Our Ref: IRH/JOH166/1
Your Ref: 2023/90956

**Land at rear of 1 Sparks Road Oakes Huddersfield HD3 4BX
Erection of 5 dwellings
Application Number 2023/90956**

3. Proposed Site Layout
Scale 1:500

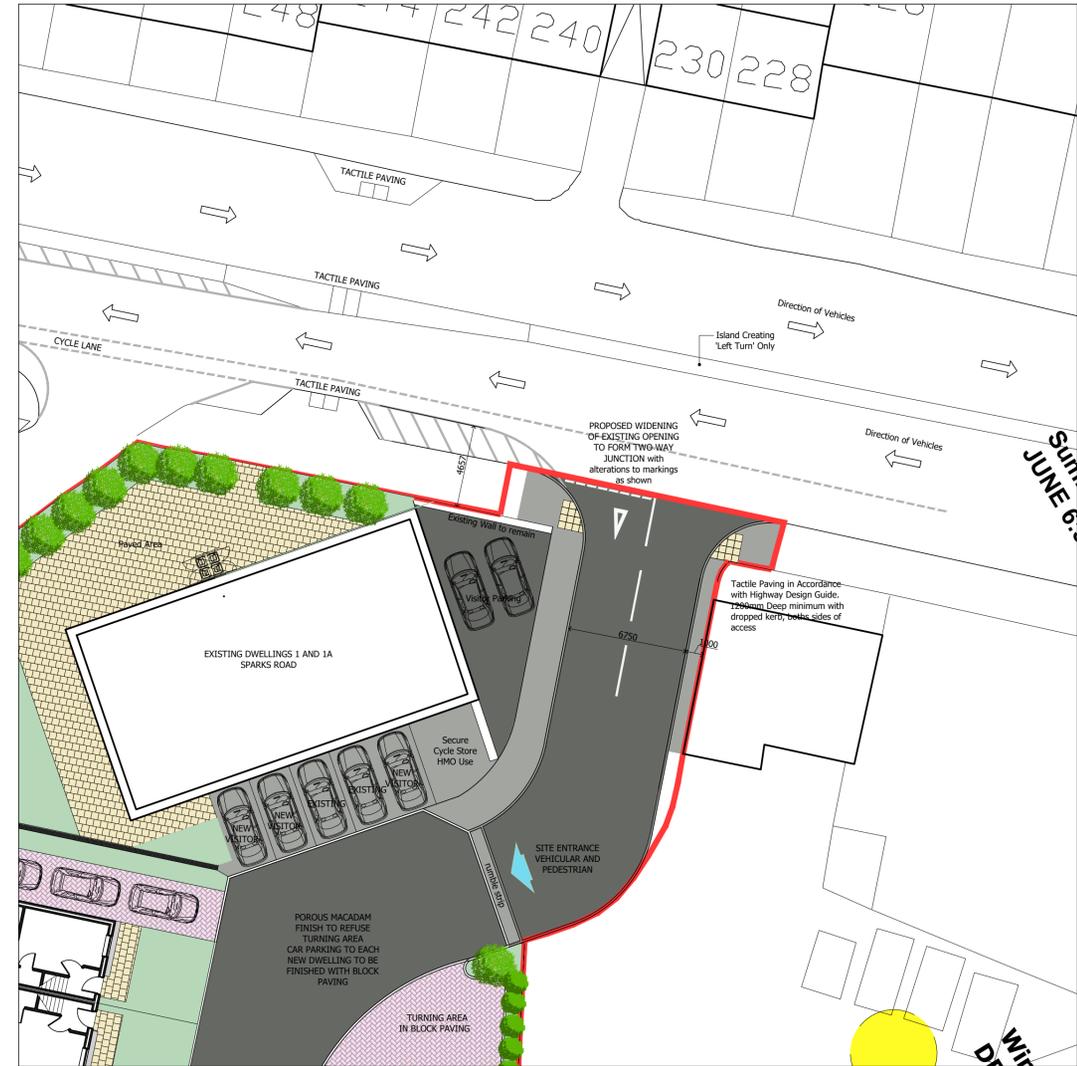
1. The property _____ is a listed building
2. Due to the close proximity to our clients property, the proposed development will adversely affect the integrity to the listed building

5. The height of the proposed buildings will over shadow the listed building and therefore adversely affect its integrity
6. The proposed buildings to the east of our clients property will look directly into habitable rooms of our clients property

7. Roof lights are not in keeping with an adjacent listed building
8. The proposed development is too intensive for the site area and its proximity to a listed building
